CITY OF ALBUQUERQUE

July 3, 2020

Re: Manual Shops
7212 Manual Blvd 87110
60-Day Temporary Certificate of Occupancy
Transportation Development Final Inspection
Engineer's/Architect's Stamp dated 6-3-19 (H19D040)
Certification dated 6-10-20

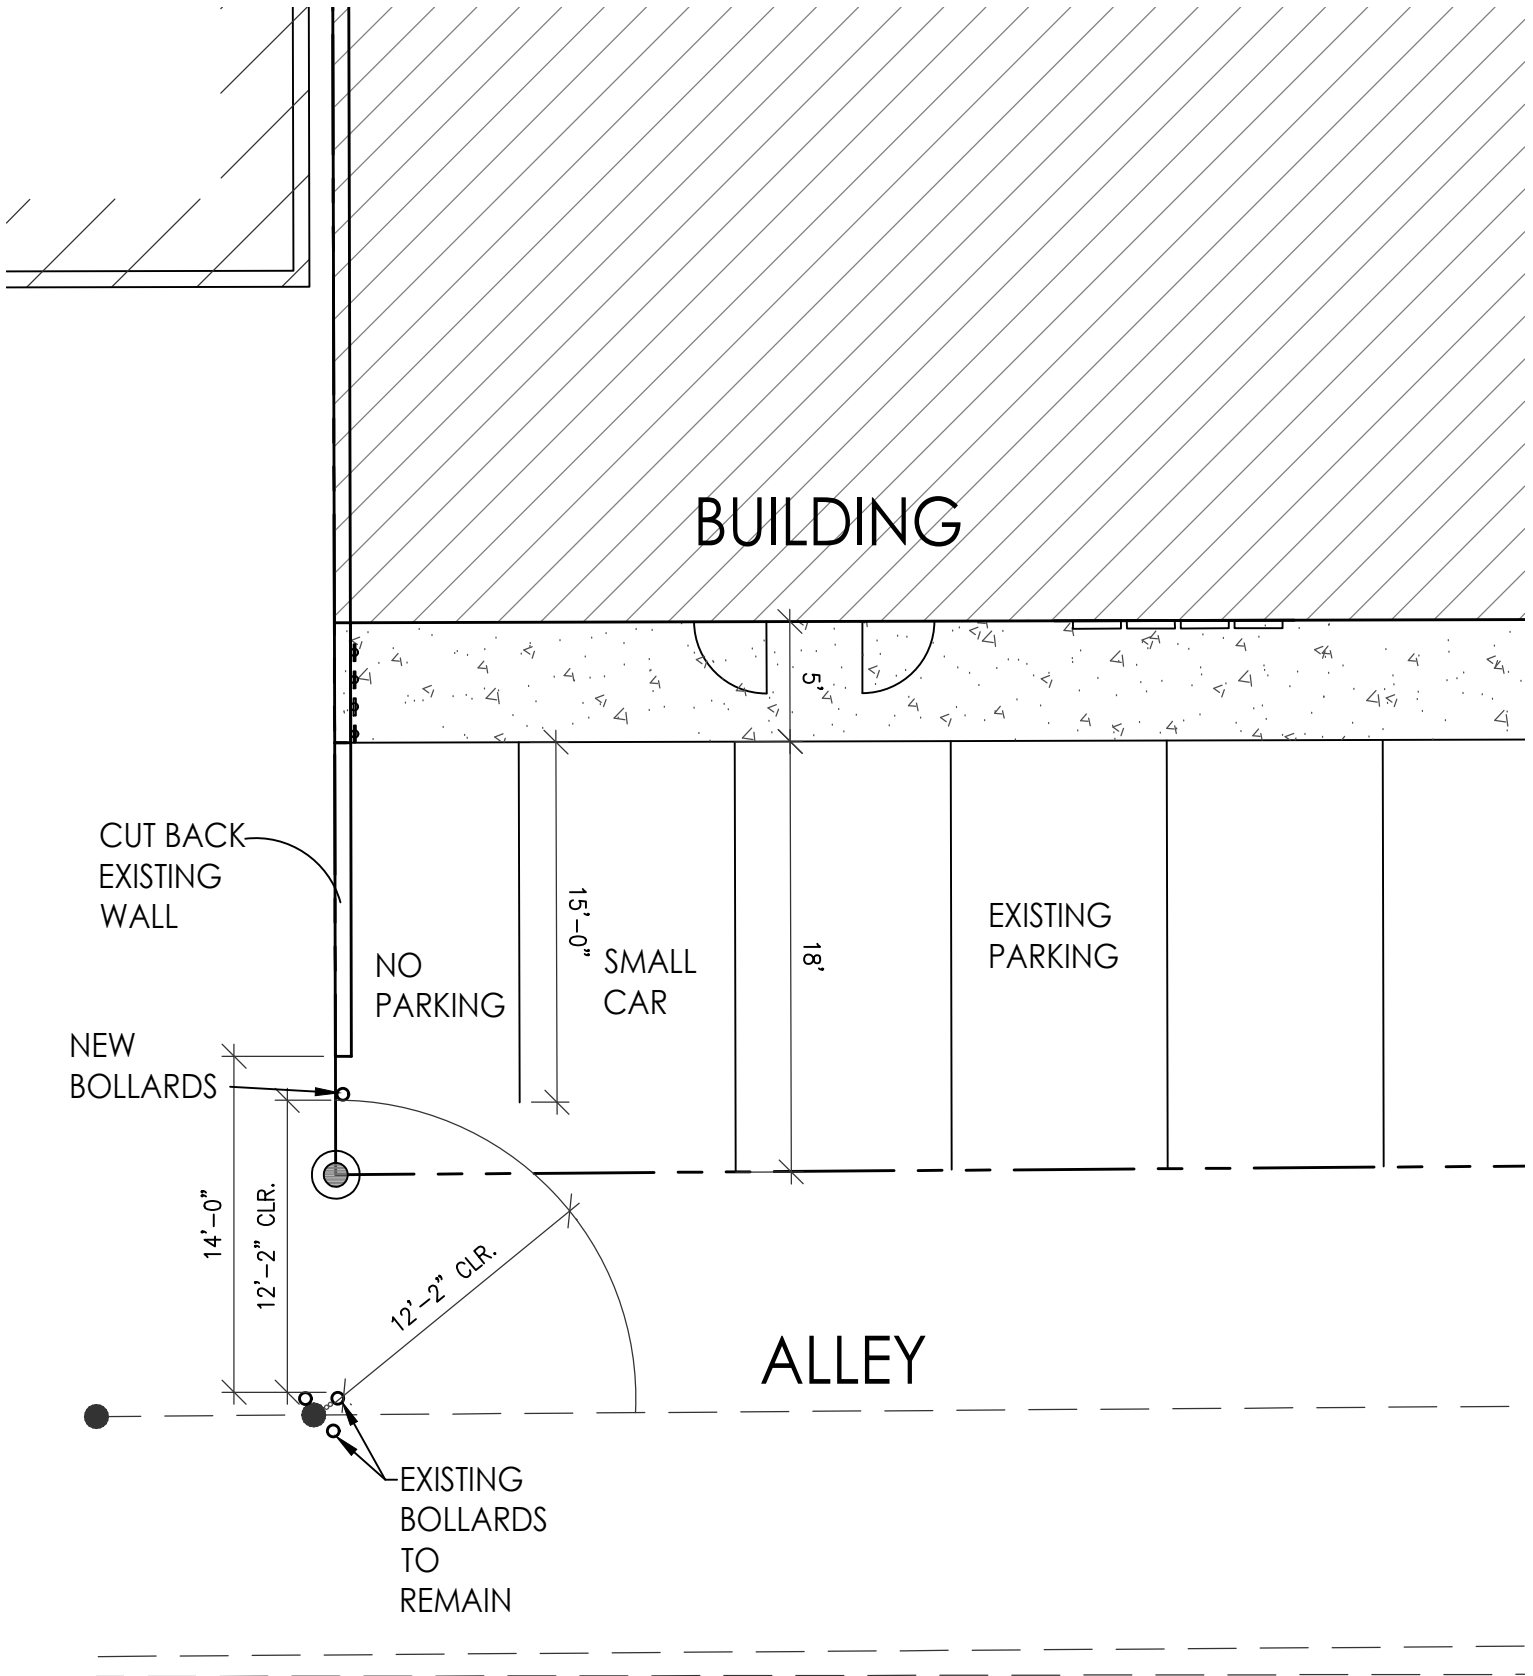
- Alley wall (Resolution Pending)...
